WELWYN HATFIELD COUNCIL – DEVELOPMENT CONTROL
DELEGATED REPORT

APPLICATION No:	S6/2008/1879/FP
------------------------	------------------------

The proposal is to convert the existing storeroom and function room to a restaurant to be used in conjunction with the existing Public House.

9150-P003

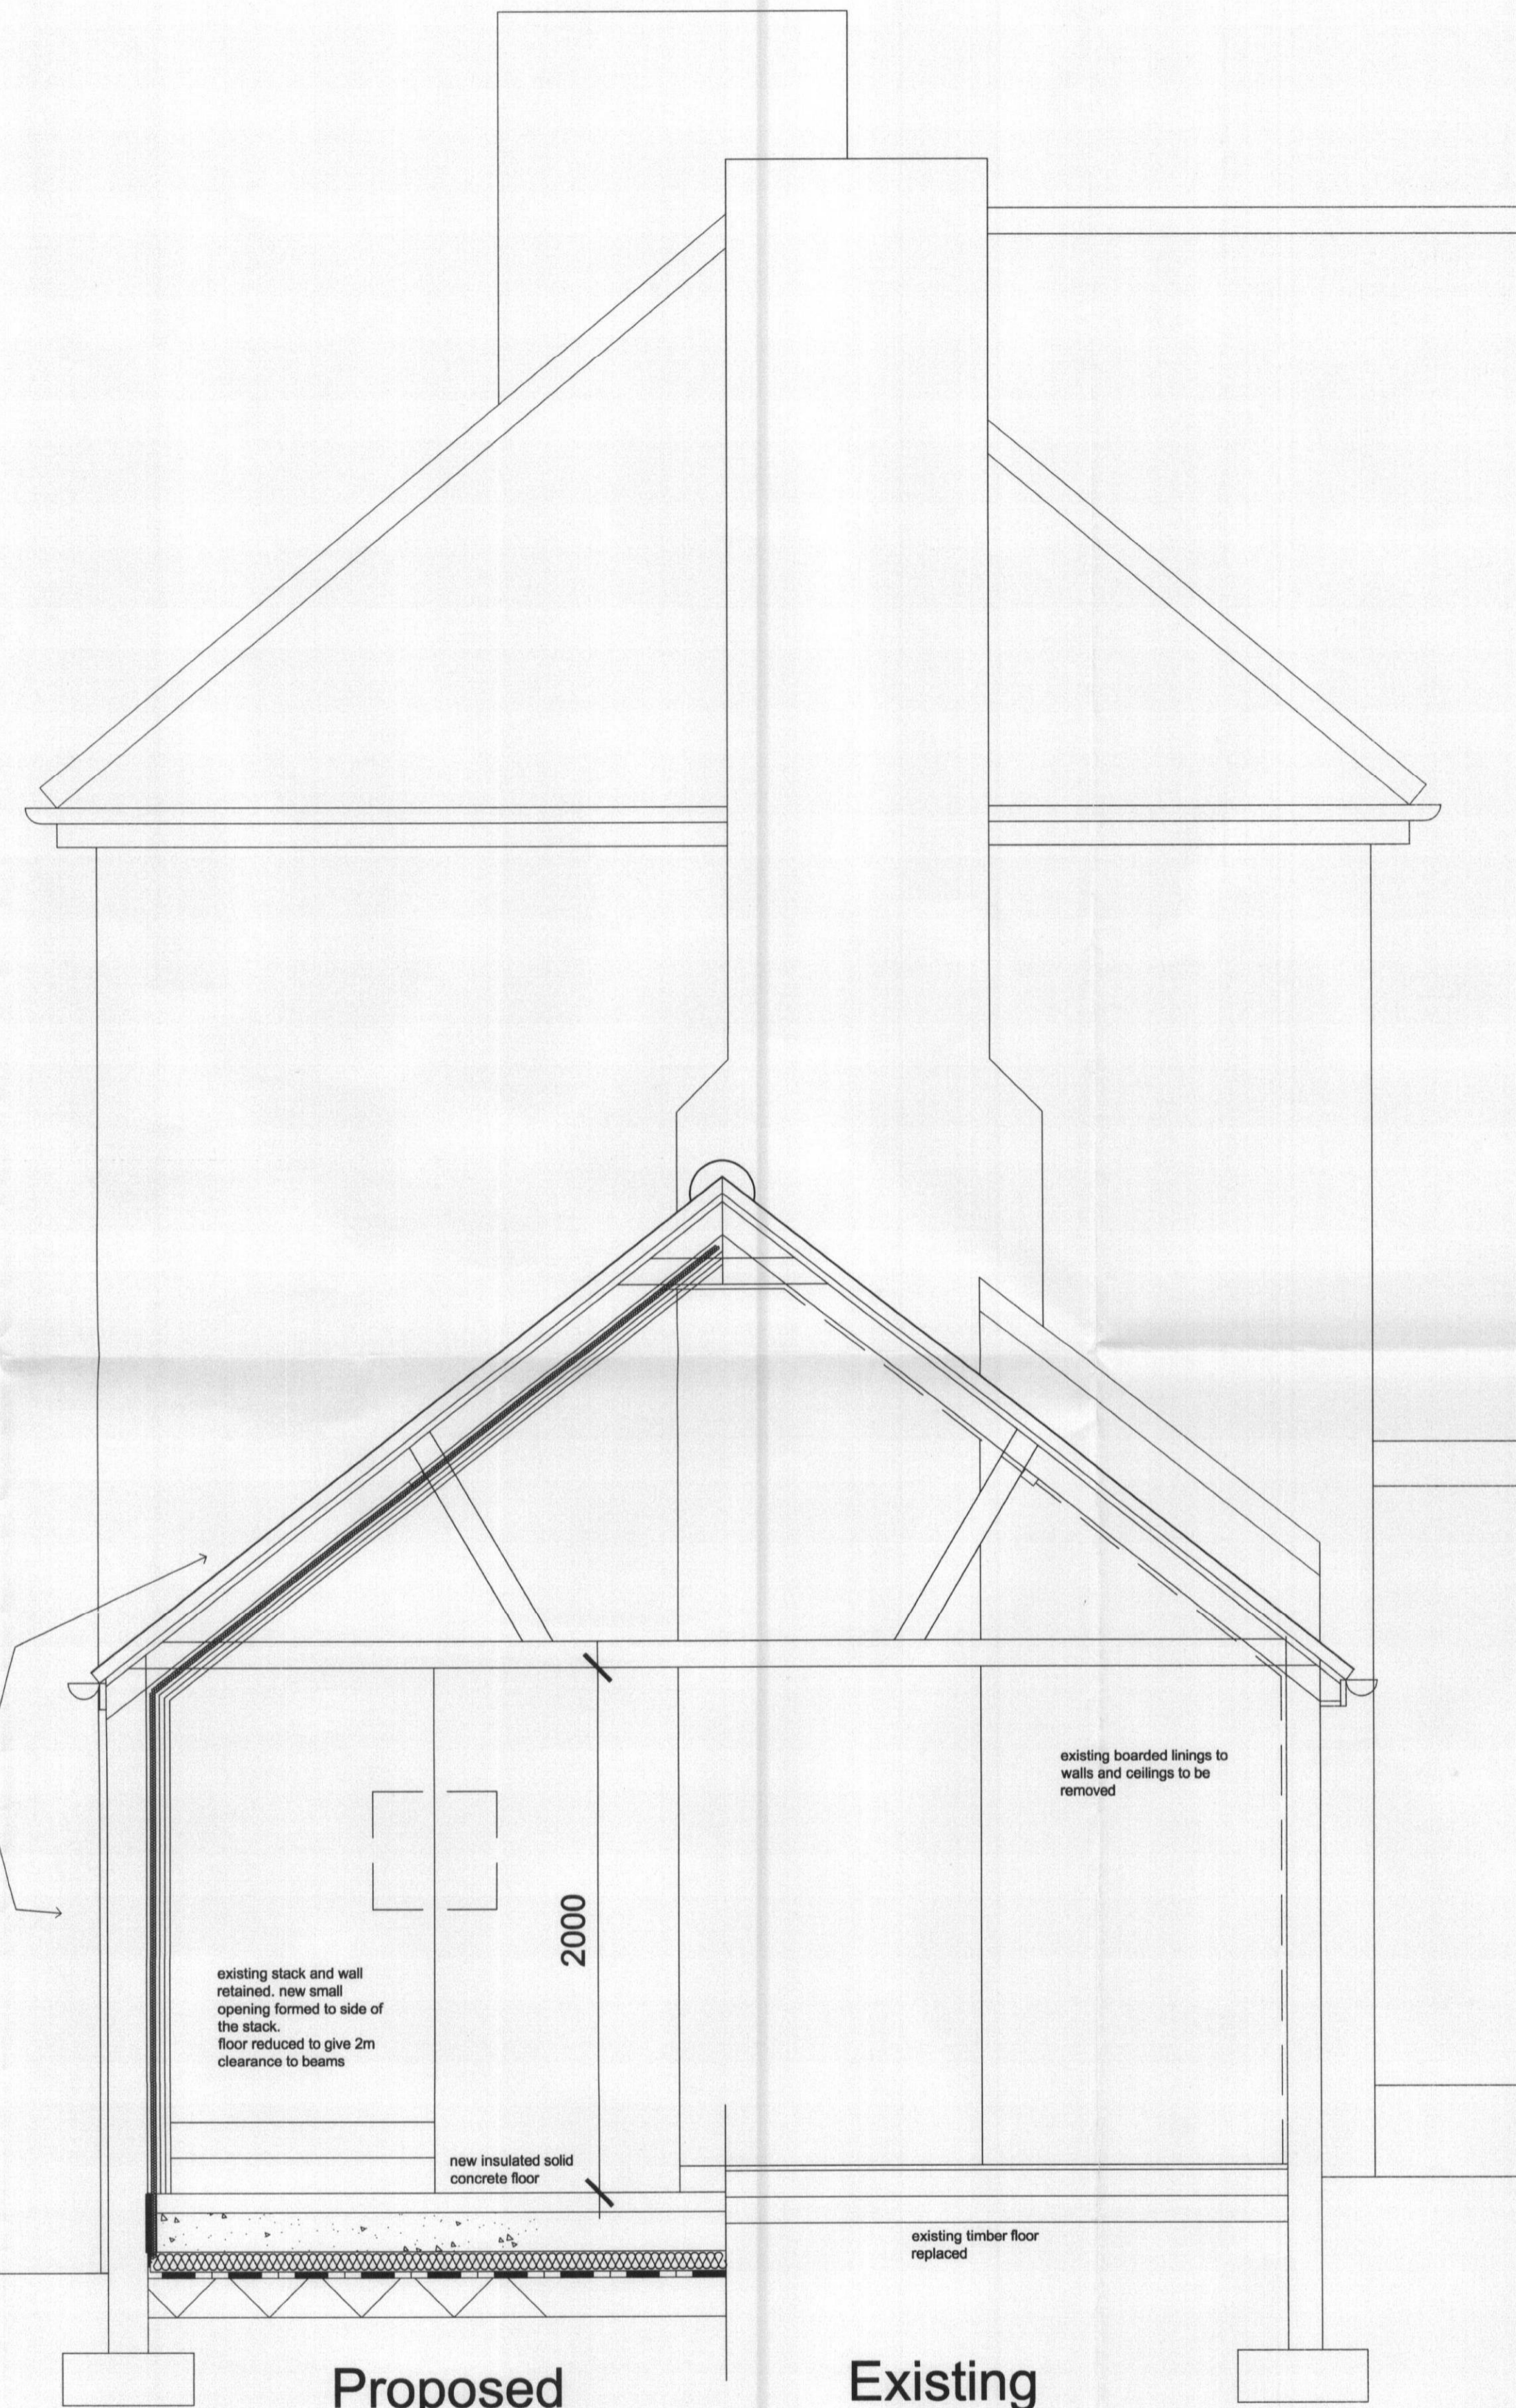
Policy R3 requires measures to maximise energy conservation through the design of buildings. The single storey structure appears to have limited insulation in regards to heat insulation. The submitted design drawing shows a section of how this will be improved and it would be reasonable to impose a planning condition to require further details of the extent of the proposed works. This work will also improve the acoustic insulation of the building as already discussed above.

6. Notwithstanding the details shown on approved drawing number 9150-P003 (date stamped 21/11/08), prior to the commencement of works, further details are to be submitted to show the extent of the proposed work in regards to the upgrade of the single storey building to comply with the energy efficiency requirements of policy R3 and the acoustic requirements given in policy R19 of the adopted Welwyn Hatfield District Plan 2005. No use of the single storey building shall take place until the approved scheme has been completed and written confirmation of approval has been received from the local planning authority. Thereafter, the sound insulation measures shall not be changed without the prior written agreement of the local planning authority.
